RE: Request for Advice - Atlassian Office and Hotel Development (SSD-10405) Central Precinct

Frank Howarth AM
Chair
Heritage Council of NSW
12 February 2021

DRAWING
SHED - SOUTHERN
ELEVATION
DOCUMENT NUMBER
DA-11C-GXX-02
ISSUE
6

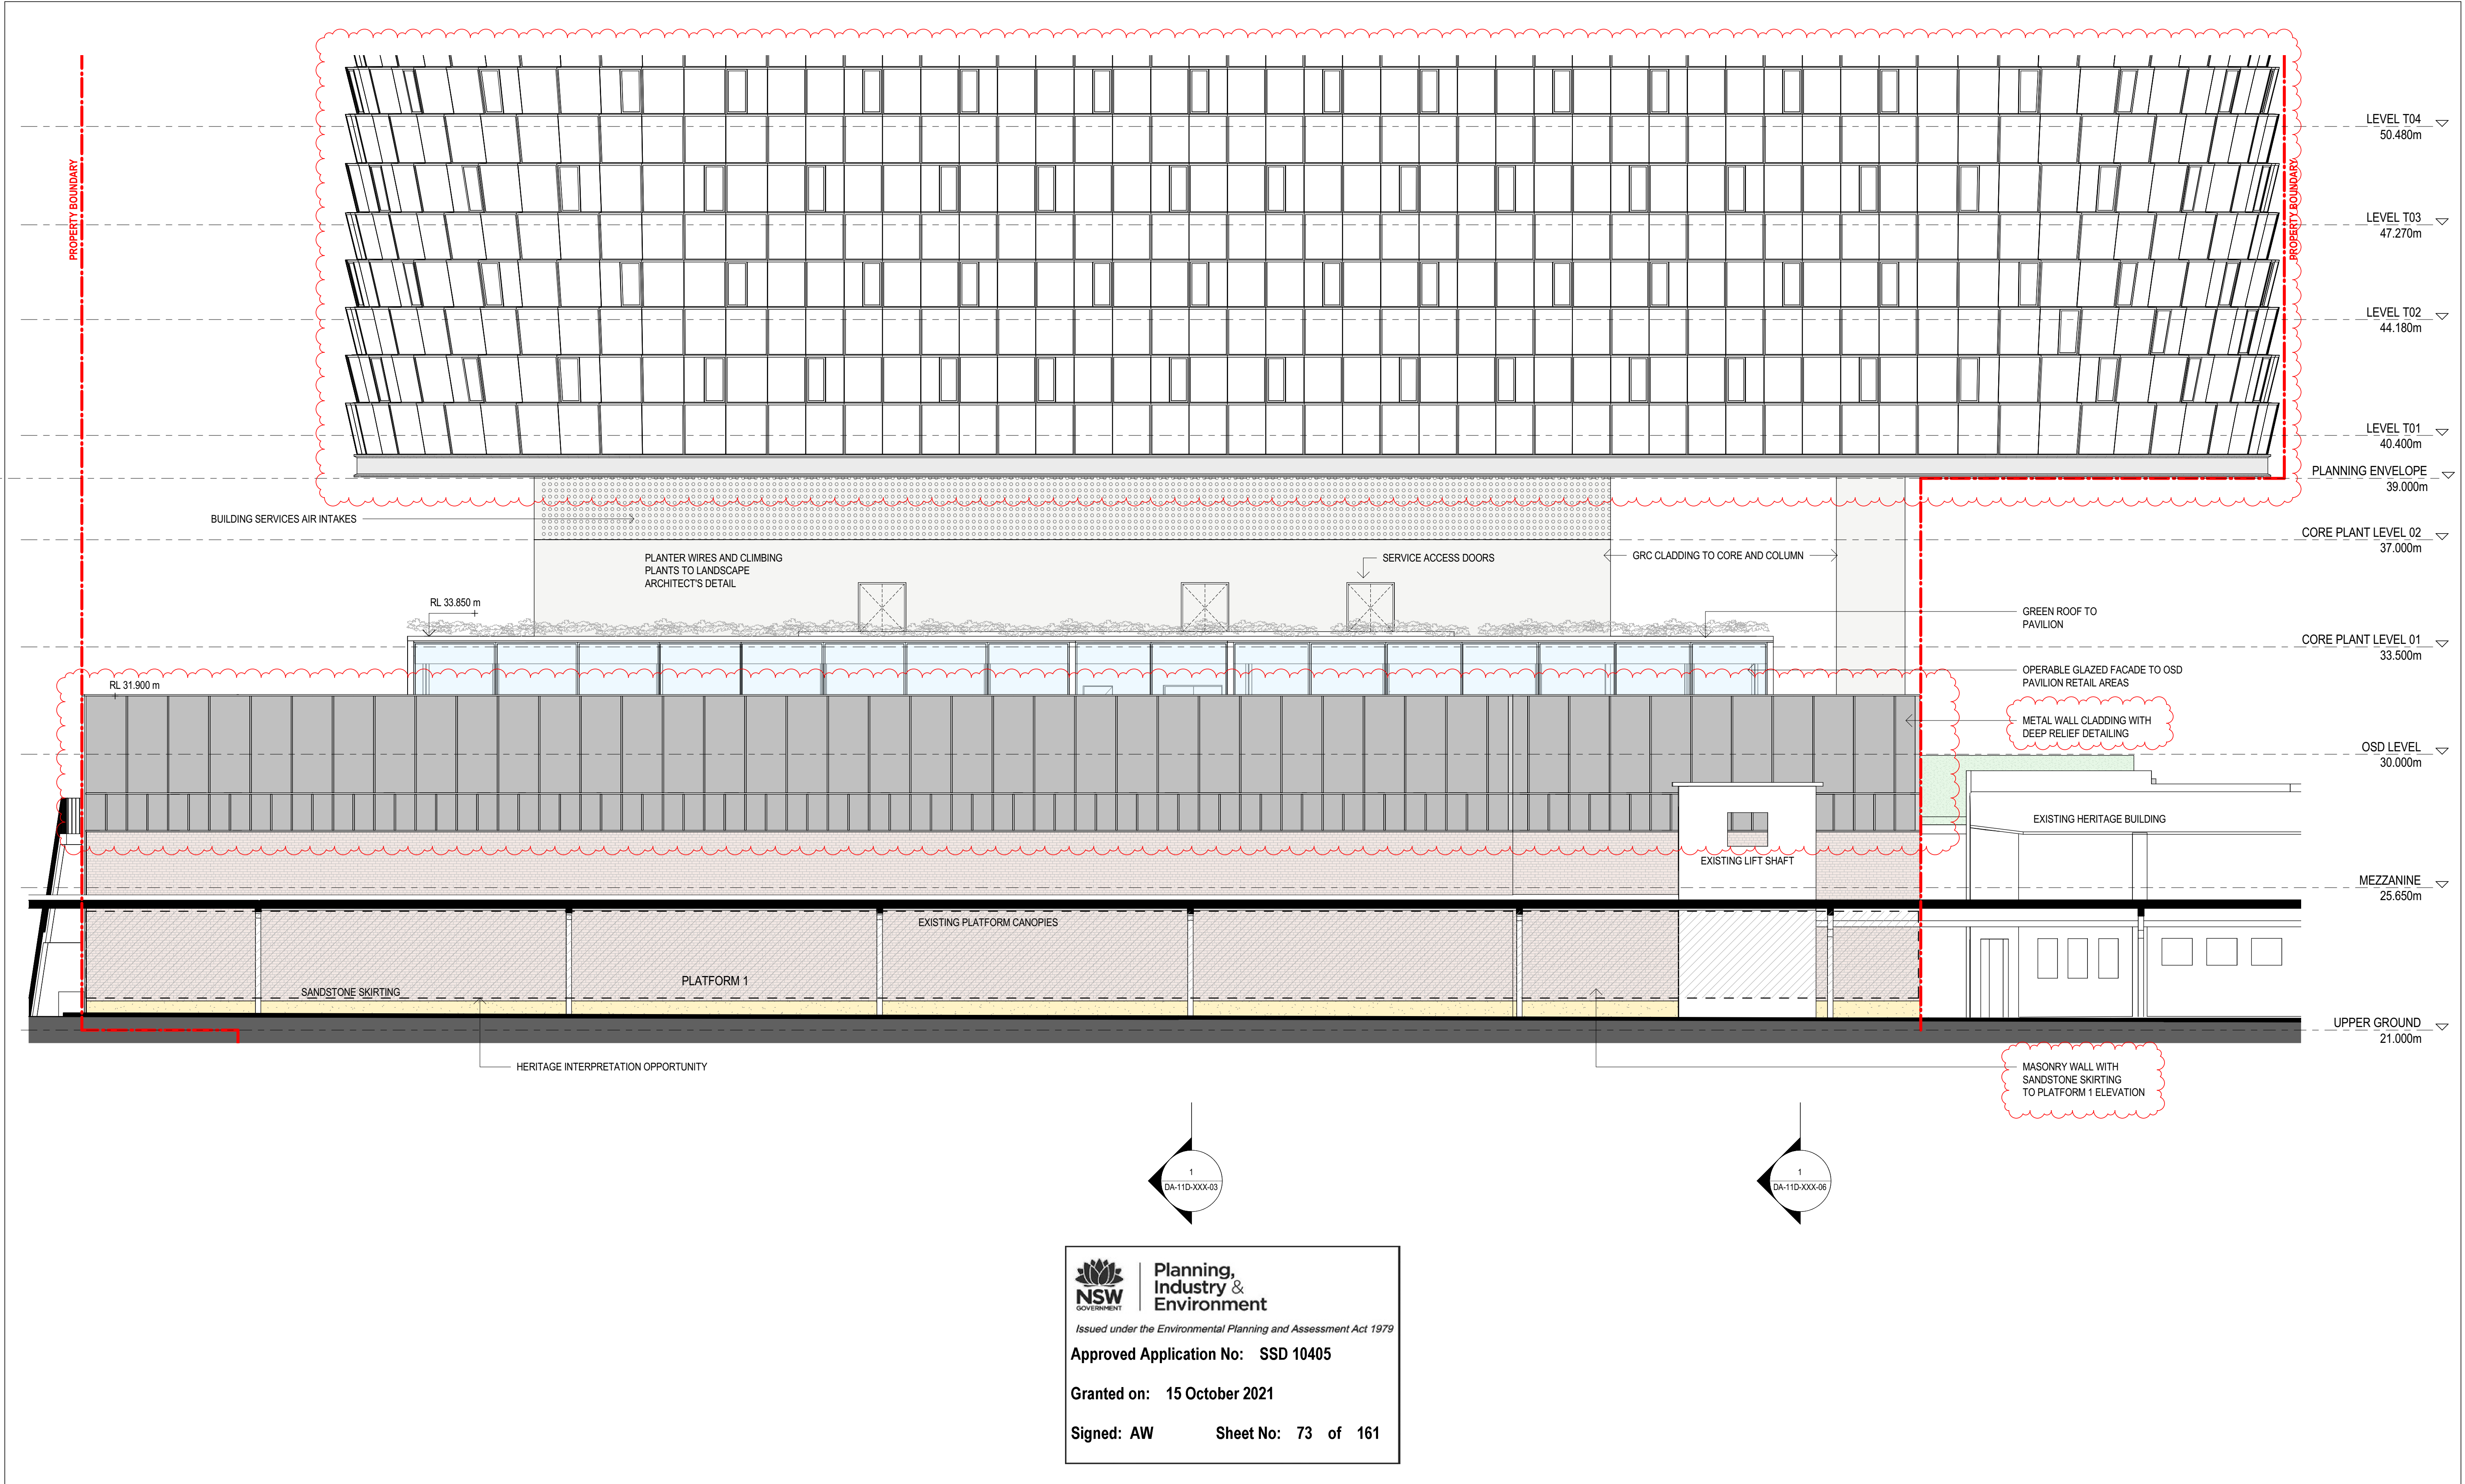
- The proposed works include demolition and partial rebuild of the Shed utilising some significant original fabric which will have obvious impacts to fabric and setting. The works, described as a reconstruction, do not align with the Burra Charter definition, which states that reconstruction means returning a place to a known earlier state. Therefore, the *Heritage Impact Statement Atlassian Central* should assess the works and resultant impacts, as an 'adaptation' rather than a 'reconstruction'.

- We recommend that the extent of demolition and removal of fabric is reduced as much as possible to minimise impact to significant/original elements.
- We note that further detail design development will be undertaken on the building and that as much original timber framing as possible will be reused in the building's adaptation. However, it is still unclear how other distinctive elements of the building, including the existing masonry base and chimneys, and sandstone plinths of the building will be meaningfully used as part of the adaptation and interpretation of the building. Further detail is required as per Heritage Council letter to the applicant, 16 October 2020.
